Planning Application 3/2012/0490 Clough Bottom Outbarn

Ian M Smith (Parish Clerk, Bashall Eaves and Mitton PC)

PROPOSED PLANS AND ELEVATIONS				
Site: Proposed Alterations Clough Bottom Barn Rabbit Lane Bashall Eaves				
Client: Mr Harry Backhouse				
Date: 22.02.12	Scale: 1:100 @ A0			
Project No: BAC/01a Dwg 02D	Drawn: DS			
Amendments:	A	B	C	D

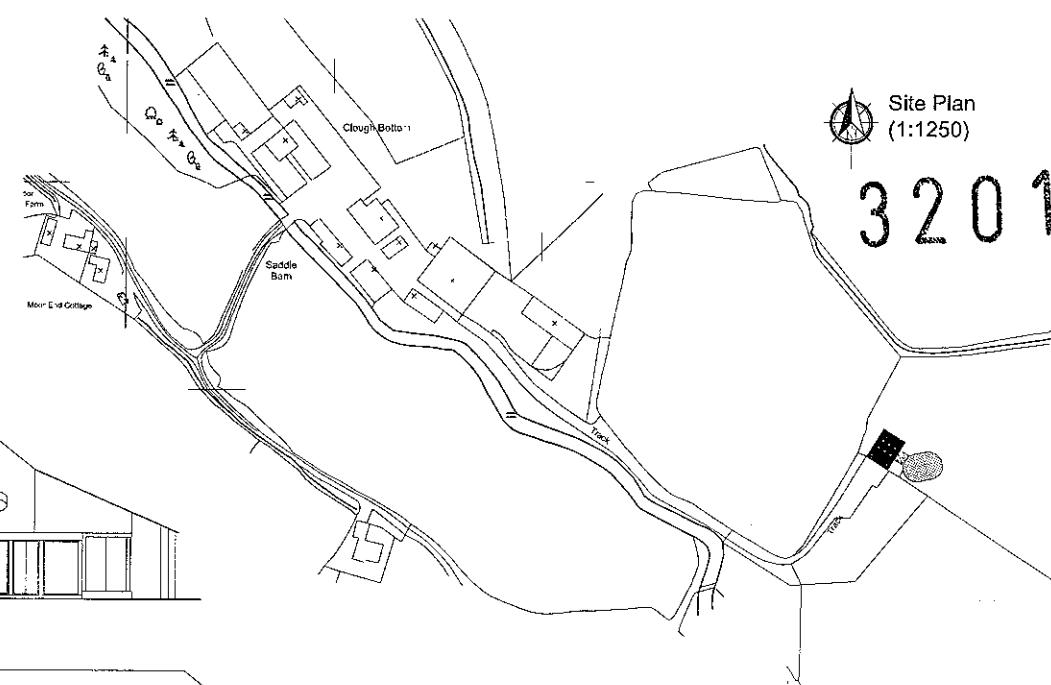
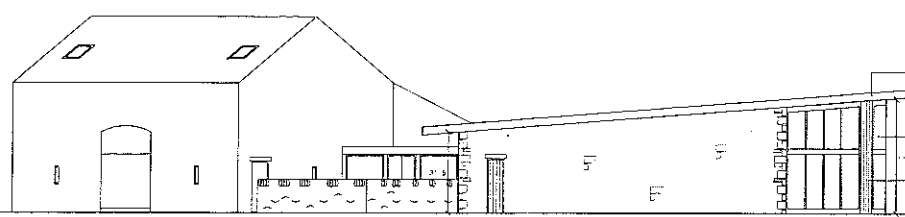
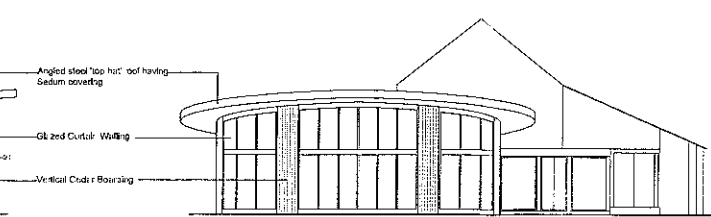
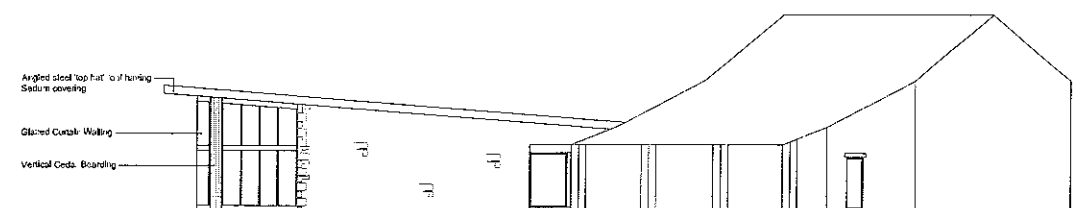
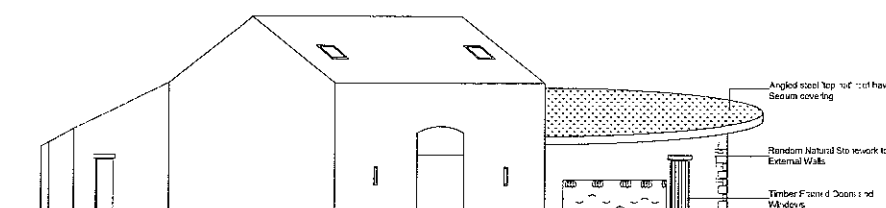
The scale of the new activity room/training centre in this location causes concern when we have been told the training business is declining. We consider the proposed oval structure will dominate and overshadow the barn and is out of character for the district and the surrounding AONB.
